**Consultation Response from KC,
Trees****2024/92713 adj, Forrest Way, 1 A, Longfield Road, Heckmondwike, WF16 9EJ****Erection of detached dwelling****Date Responded: 03/12/2024****Responding Officer: JD****Responding Ref: 10/10**

PROPOSED SINGLE PLOTS. ALL ELEVATIONS

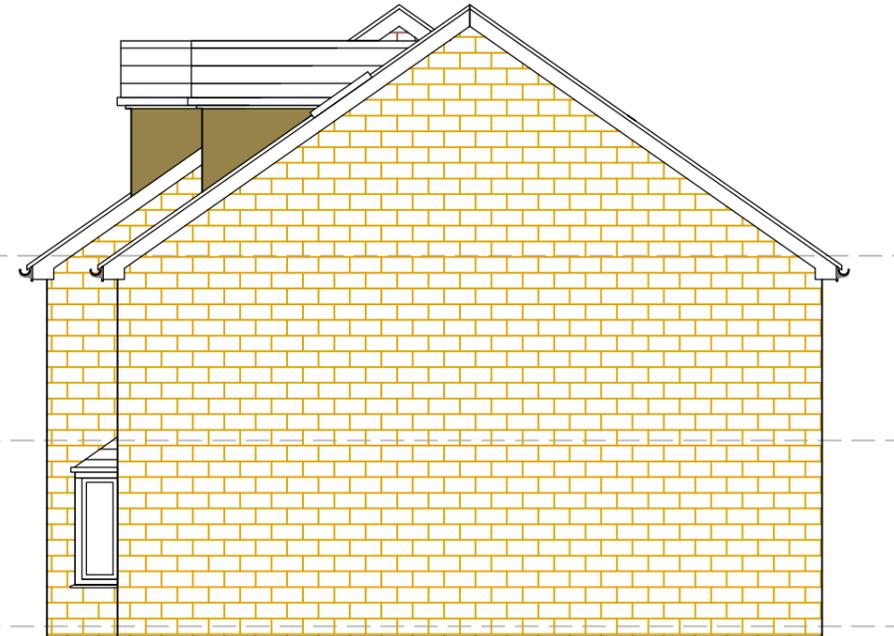
The current proposals look to suggest some trees would require removal to facilitate the development. This would be in conflict with adopted local planning policy 33 and 24(i).
